# Sydney Metro Martin Place

## North Tower Base Building Changes

*SSDA Stamped plans & FC2 Comparison*

*Rev #01 – 15/03/22*

**SYDNEY METRO - MARTIN PLACE
LEVEL 05 PLAN
GENERAL ARRANGEMENT**

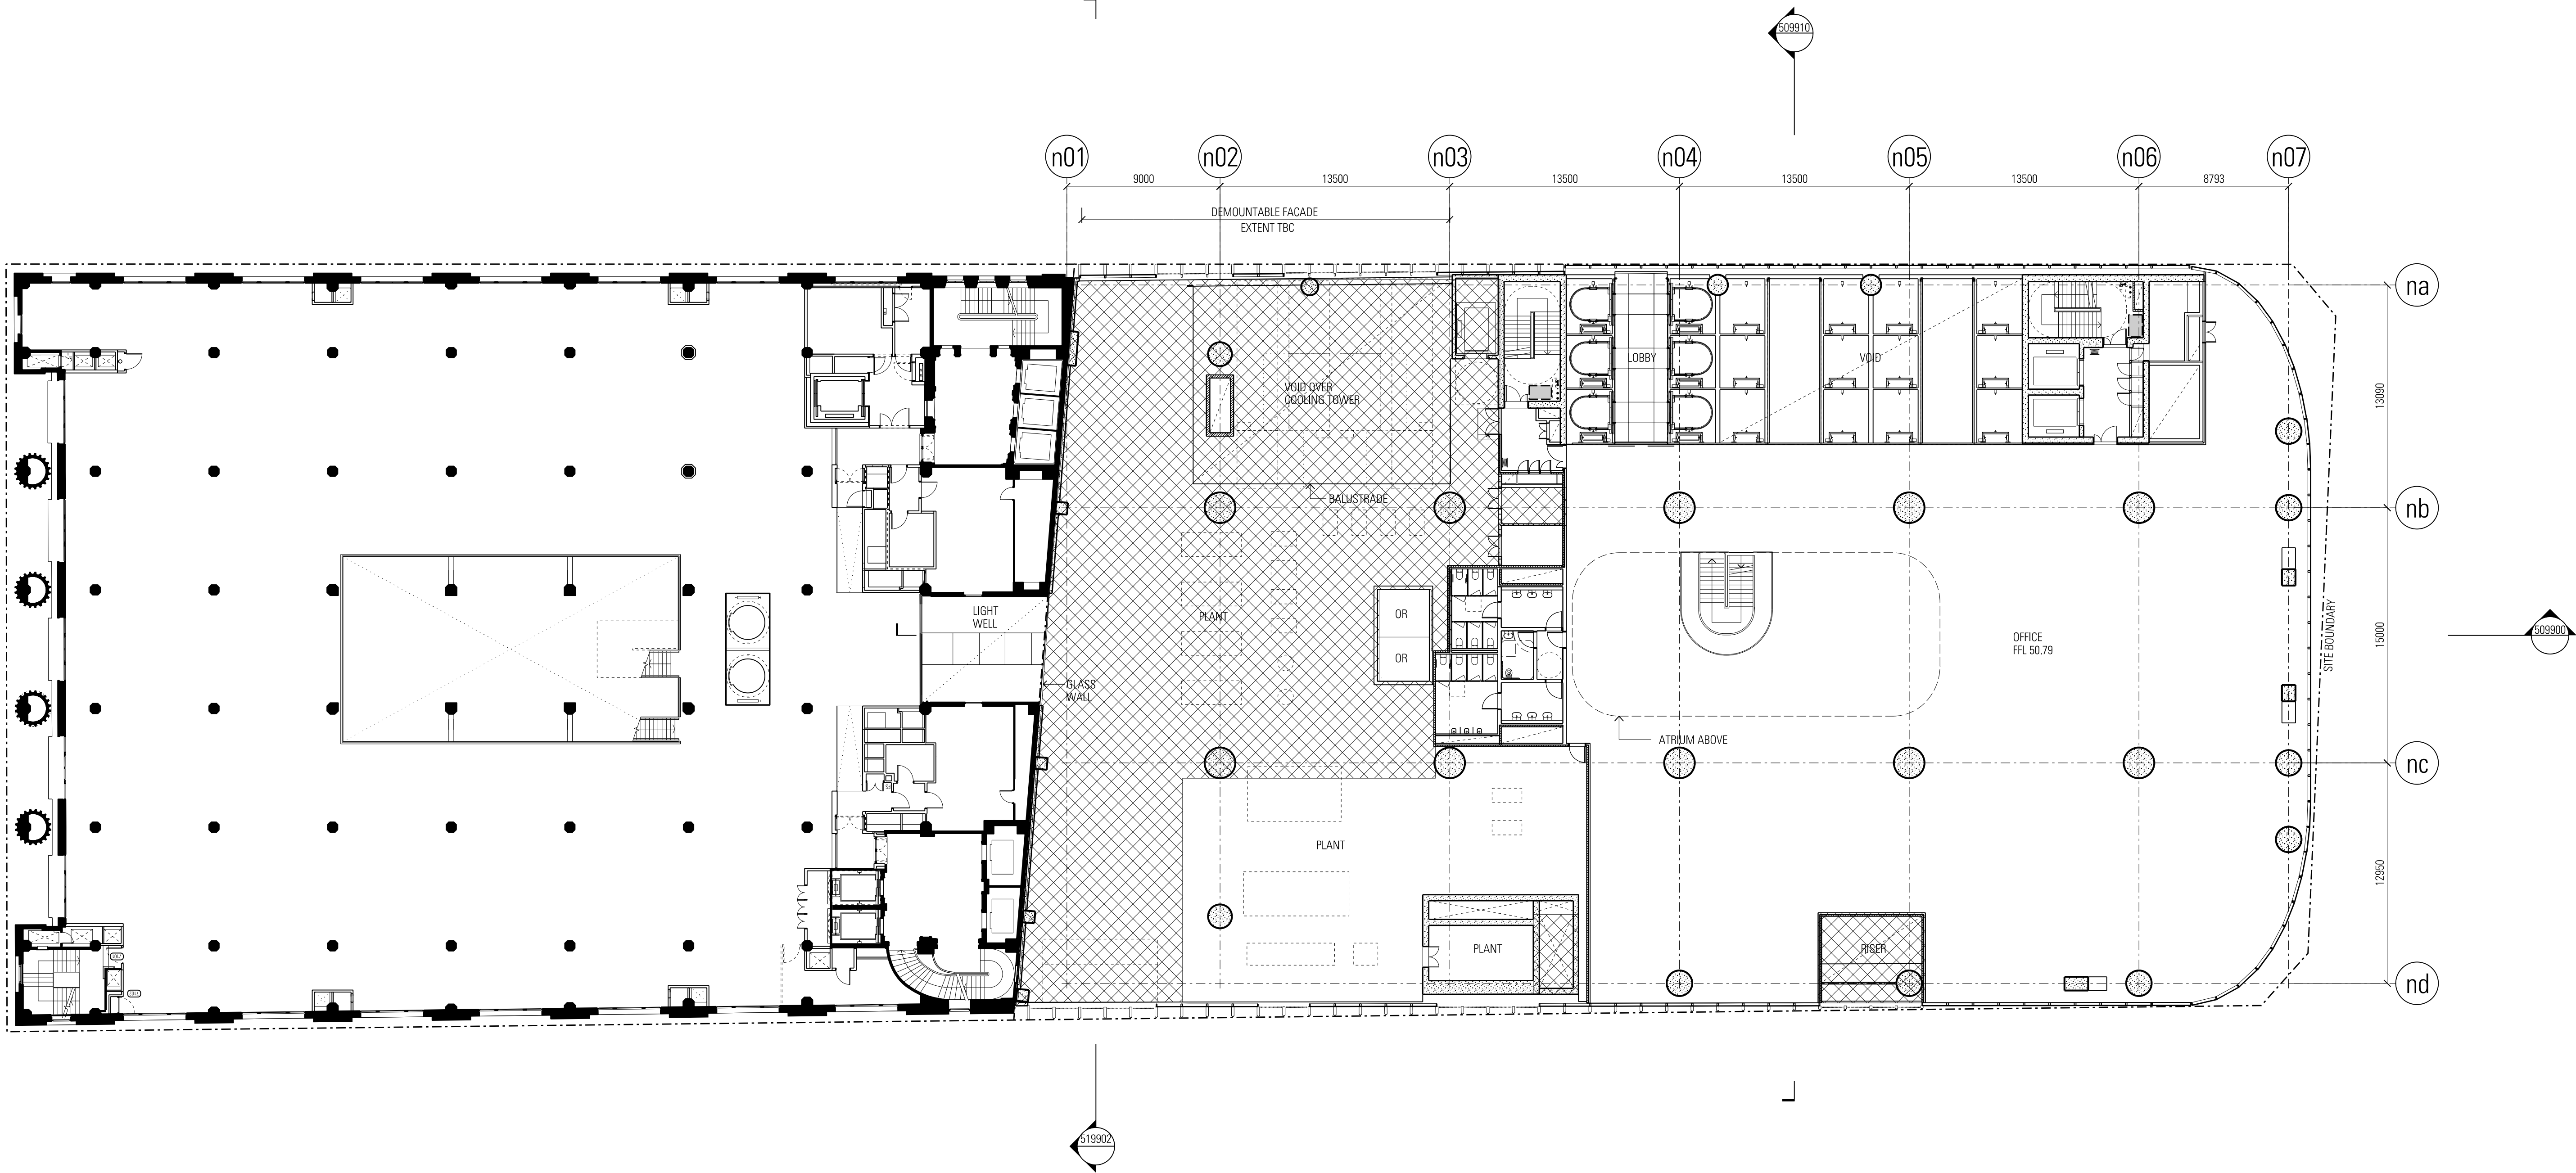
1. Relocation of tenant plant from Level 5 to Level 6.

Drawing Title  
SYDNEY METRO-MARTIN PLACE WEST ELEVATION  
GENERAL ARRANGEMENT

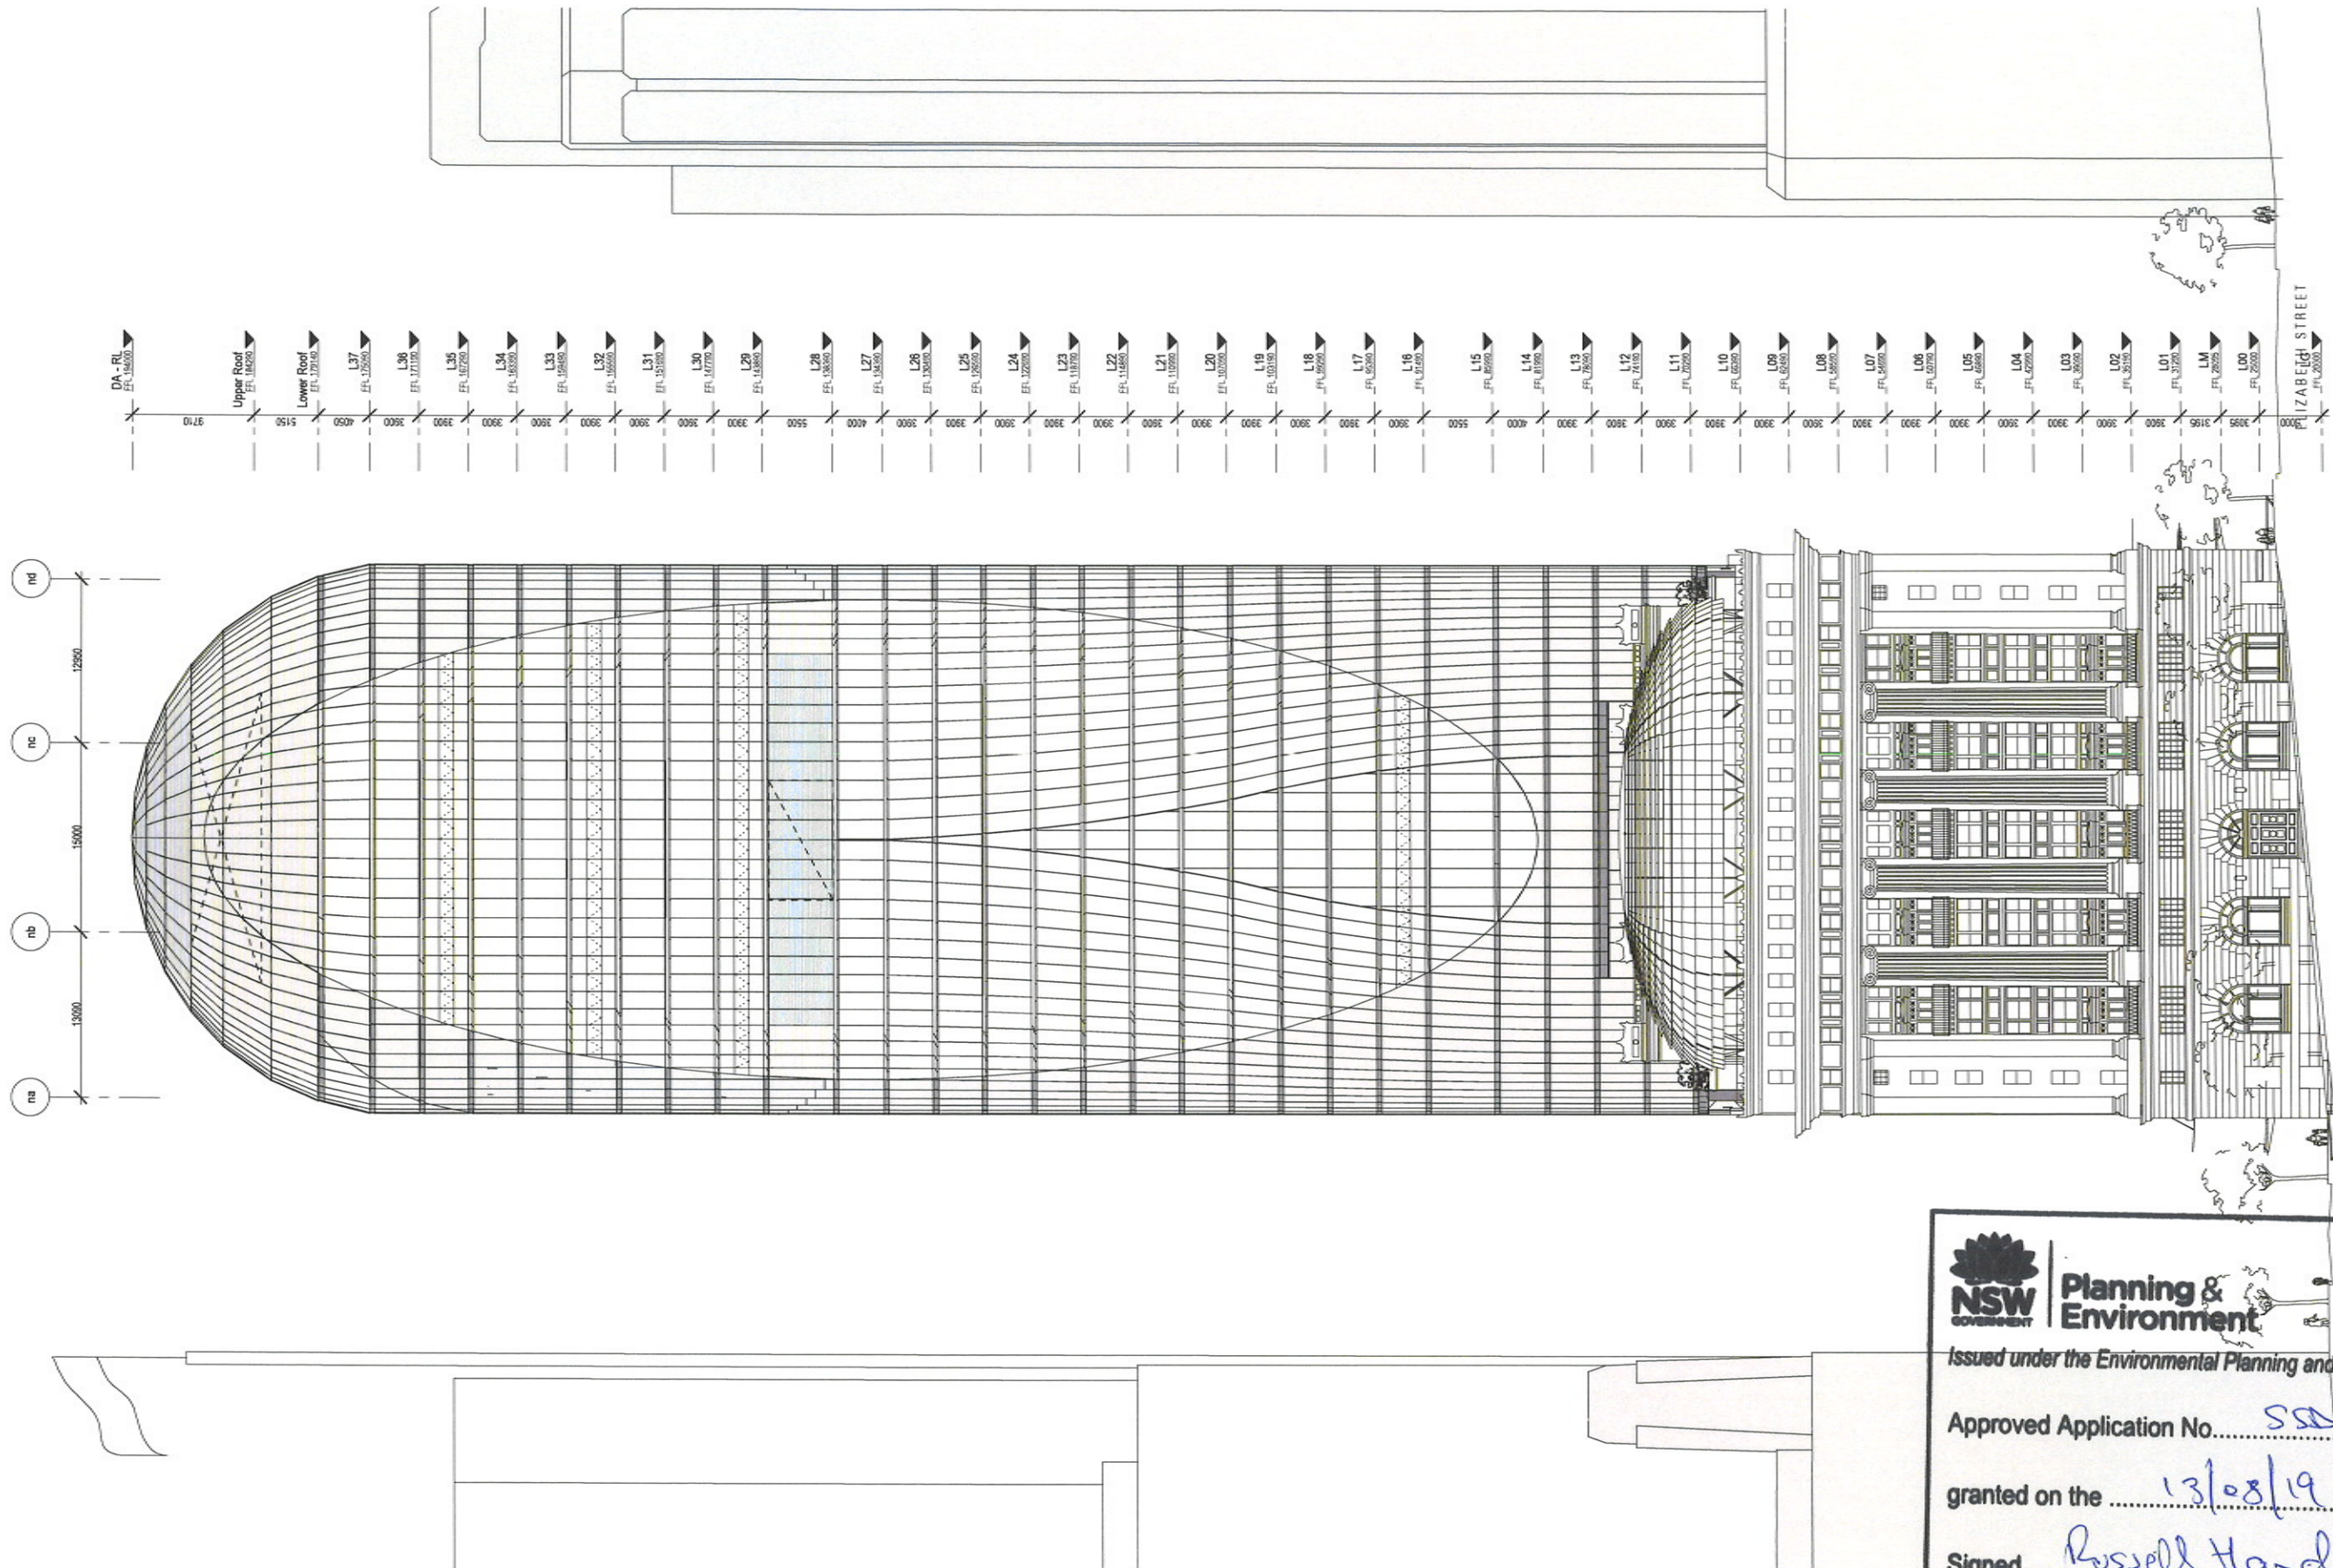
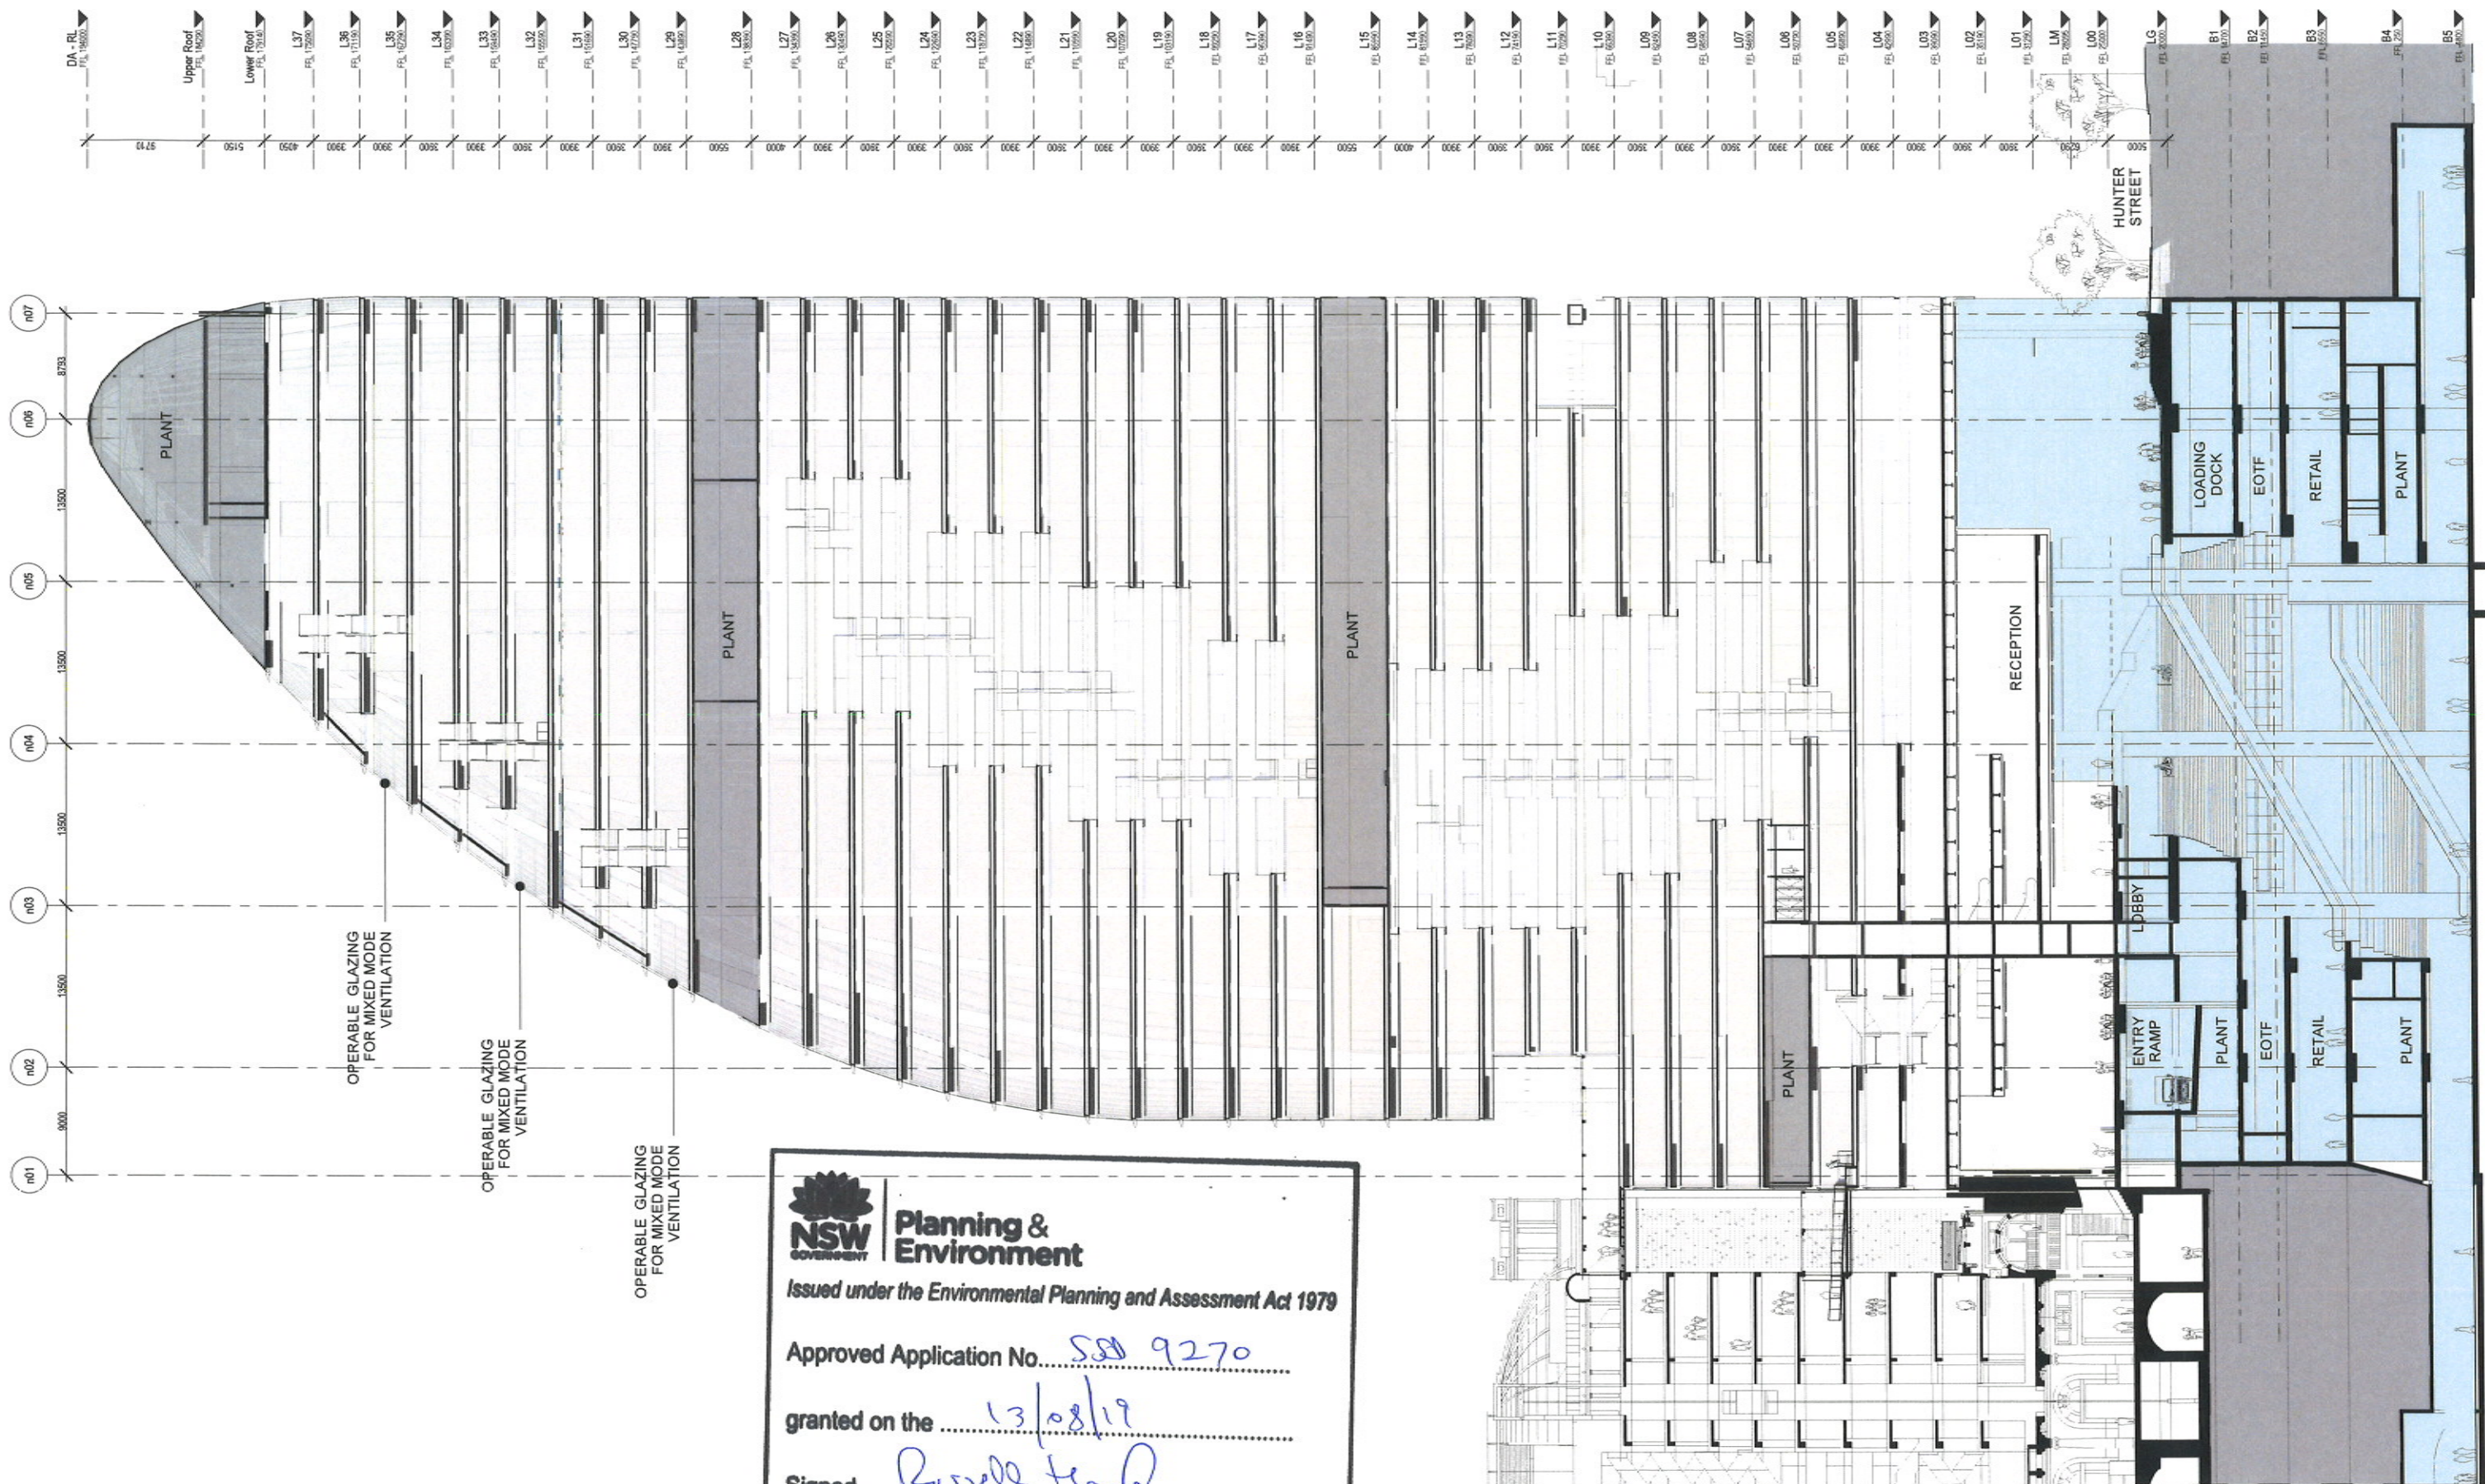
1. Increase in louvres on level 15 in lieu of glazing on western facade
2. Increase in louvres on level 28 in lieu of glazing on western facade
